Acceptance of Applications Checklist

South East Anglia Link Section 55 Acceptance of Applications Checklist

Section 55(2) Acceptance of applications				
1	Within 28 days (starting day after receipt) The Planning Inspectorate must decide whether or not to accept the application for examination.	Date received	28-day due date	Date of decision
		27 March 2025	24 April 2025	23 April 2025
Section 55(3) – the Planning Inspectorate may only accept an application if it concludes that:		Planning Inspectorate comments		
Section 55(3)(a) and s55(3)(c): It is an application for an order granting development consent				
2	In accordance with sections(s) 14 to 30 of the Planning Act 2008 (the PA2008), is the development a Nationally Significant Infrastructure Project (NSIP) (or does it form part of an NSIP); and does the application state on the face of it that, in accordance with s31 of the PA2008, it is an application for a development consent order (DCO) under the PA2008, or equivalent words? Does the application specify the development to	Yes Section 4 of the Application Form (Doc 1.2) states: <i>“The Proposed Project is to reinforce the transmission system in the South East of England and E

THE NATIONAL GRID (SEA LINK) ORDER  
PINS APPLICATION NUMBER: EN020026  
STATUTORY AND NON-STATUTORY SITES OF NATURE  
CONSERVATION, GEOLOGICAL AND LANDSCAPE  
IMPORTANCE PLANS - KENT  
REGULATION 5(2)(f)(i)  
SHEET 5 OF 6

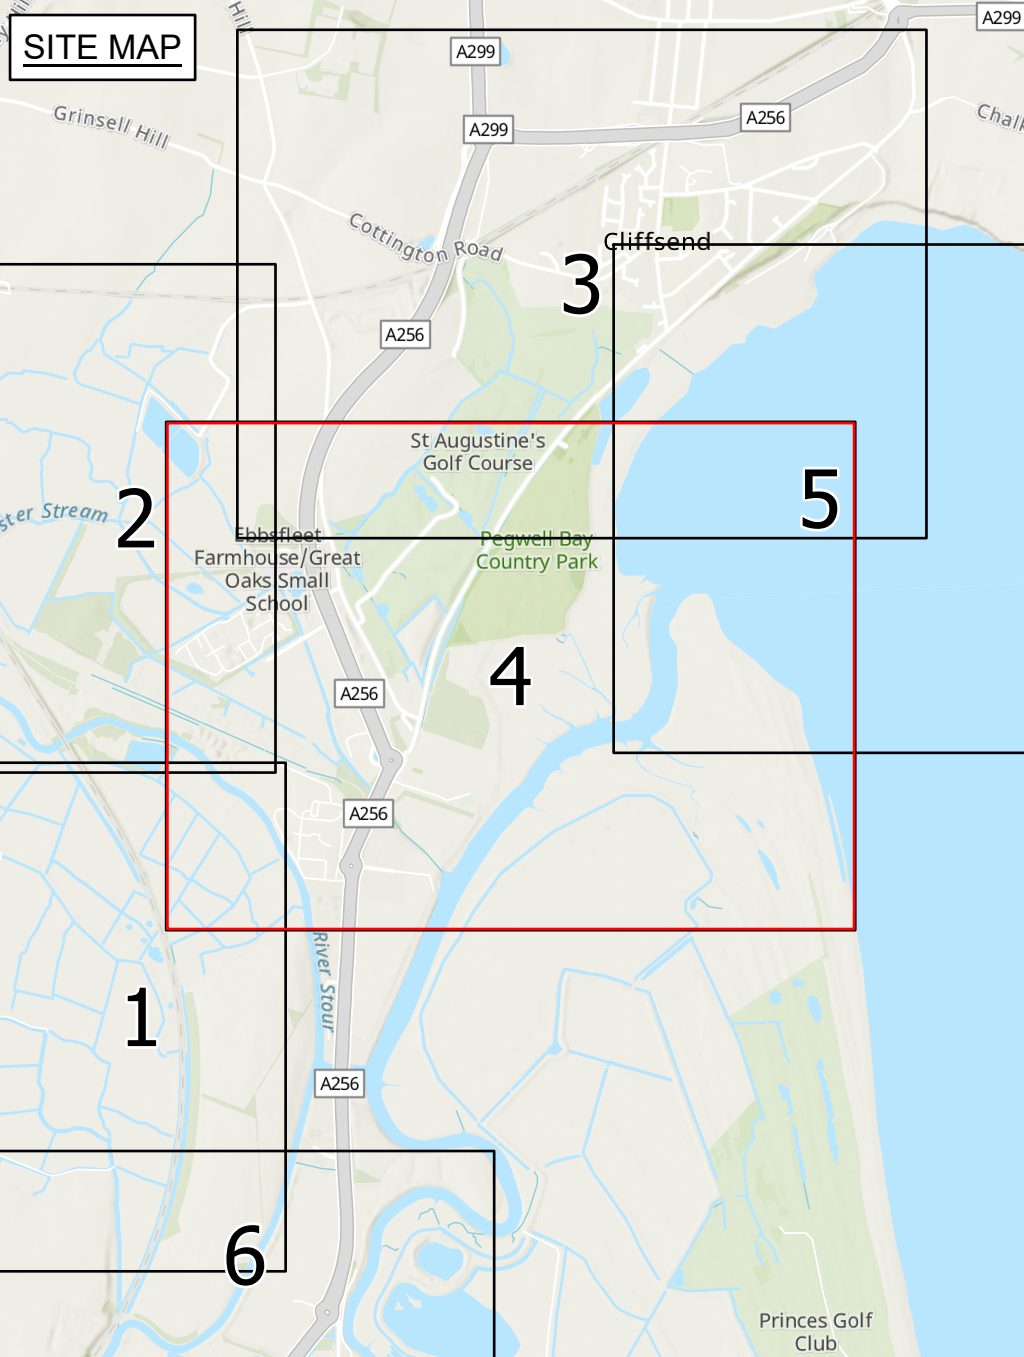
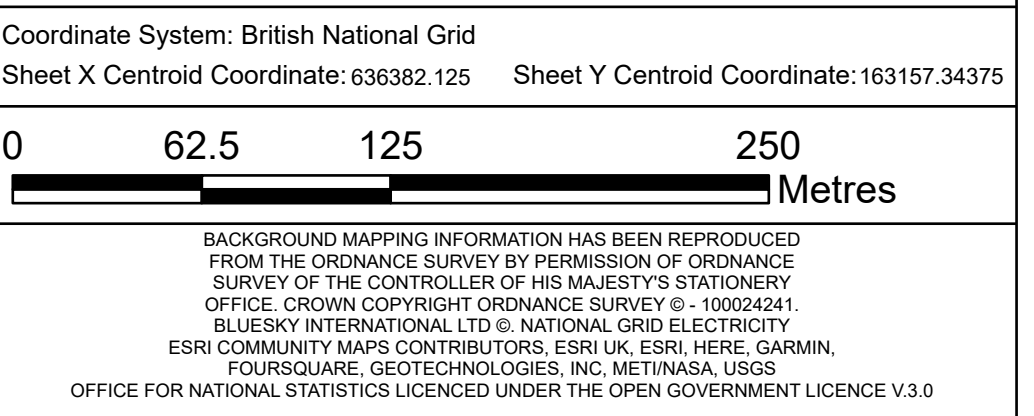
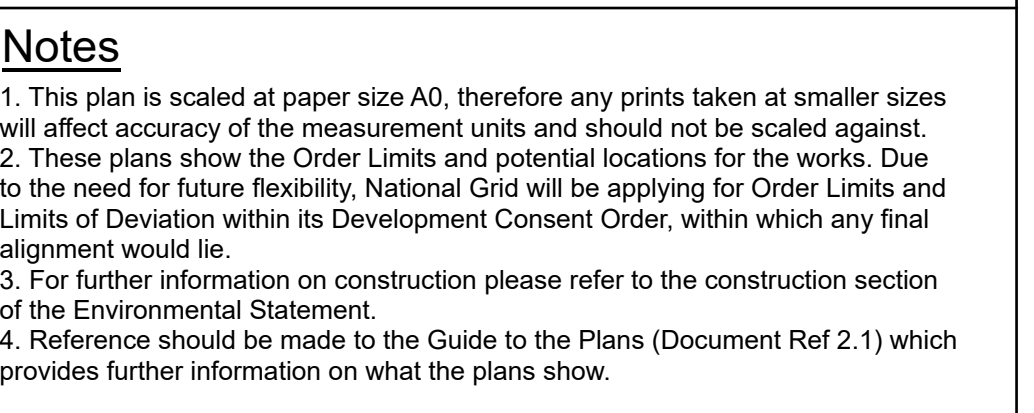
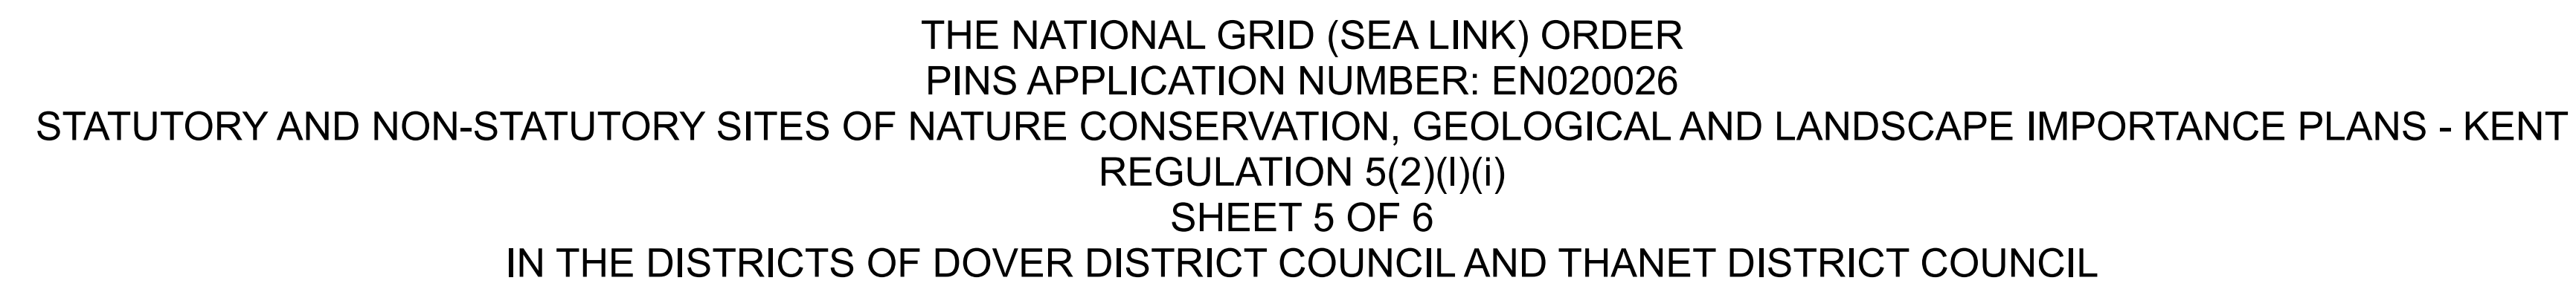
Design Approach Document – Suffolk (Doc ref 7.11.1) Design Approach Document – Kent (Doc ref 7.11.2) Design Principles – Suffolk (Doc ref 7.12.1) Design Principles – Kent (Doc ref 7.12.2) Corridor Preliminary Routing and Substation Siting study (October 2022) (Doc ref 8.1) Options Selection and Design Evolution Report (October 2023) (Doc ref 8.2) Strategic Options Report (Doc ref 8.3)
	Are they of a satisfactory standard?	N/A		Are they of a satisfactory standard?	Yes, with minor discrepancies as noted in Box 30
30	Are there any observations in respect of the documents provided at box 29 (a) to (q) above?				
	Access, Rights of Way and Public Rights of Navigation Plans (Doc 2.7) Some of the road names are not marked in the plans as mentioned in the Schedule 5 – Streets subject to street works. For example – Leiston Road is listed in Schedule 5 to be on the Sheet 5 of Plans but is not marked on the plan.
